# CITY OF ALBUQUERQUE

**Re: Snow Vista Substation PNM  
Grading and Drainage Plan  
Engineer Stamp dated 4-5-2012 (M09/D028)**

Re: Public Service Company of New Mexico Substation by the Amole Channel, ZAP m-9  
 Engineer's Stamp Dated April 5, 2012

RIP RAP SPILLWAY #1 DETAIL

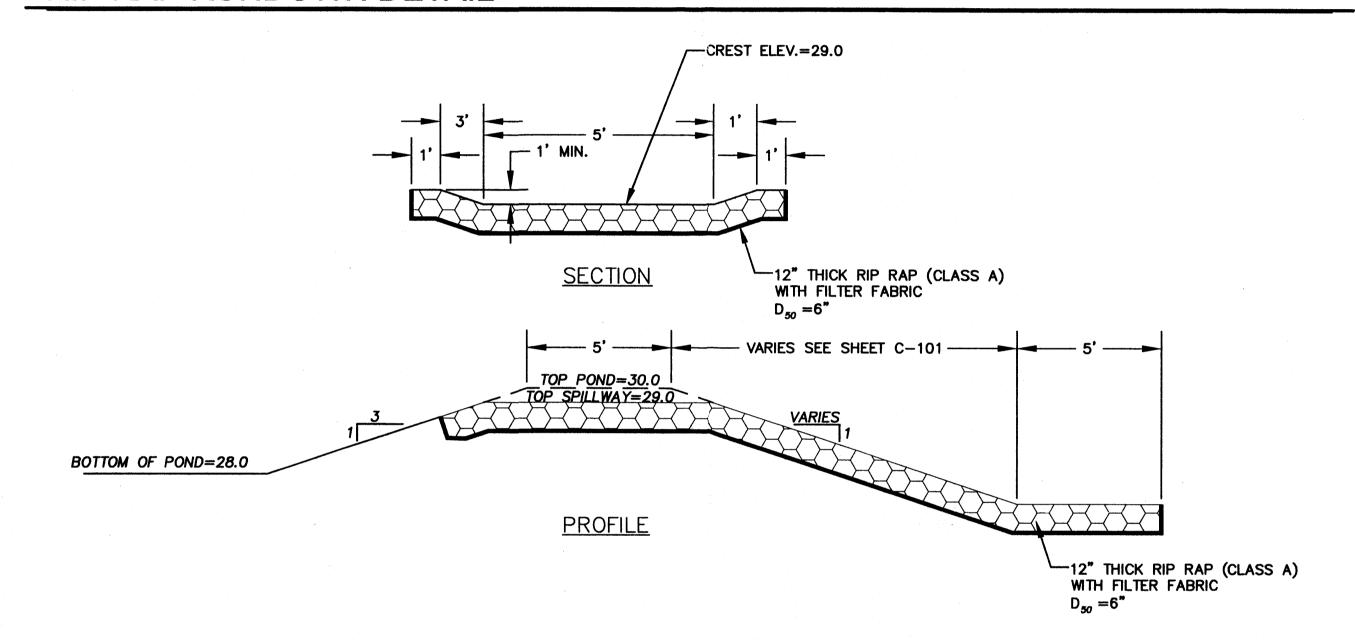
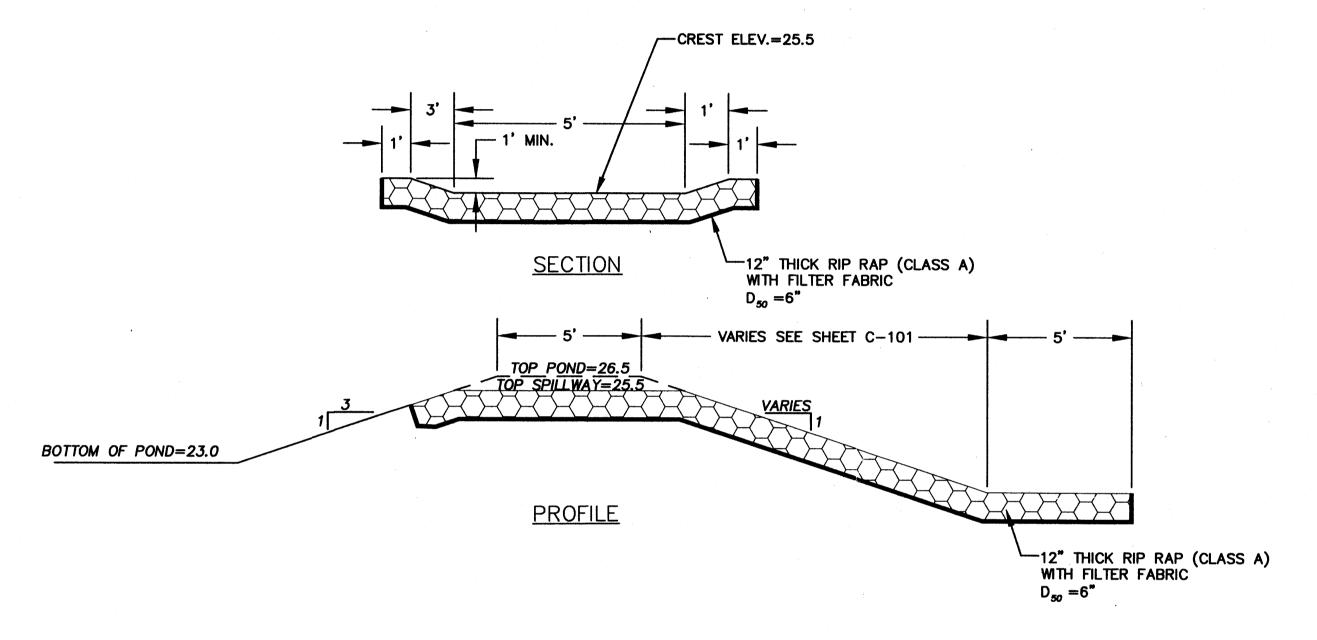
AMAFCA approves the grading and drainage plan for the subject project. The spillways from the retention ponds are for emergency overflow and, therefore, will not require additional riprap lining in the AMAFCA right-of-way.
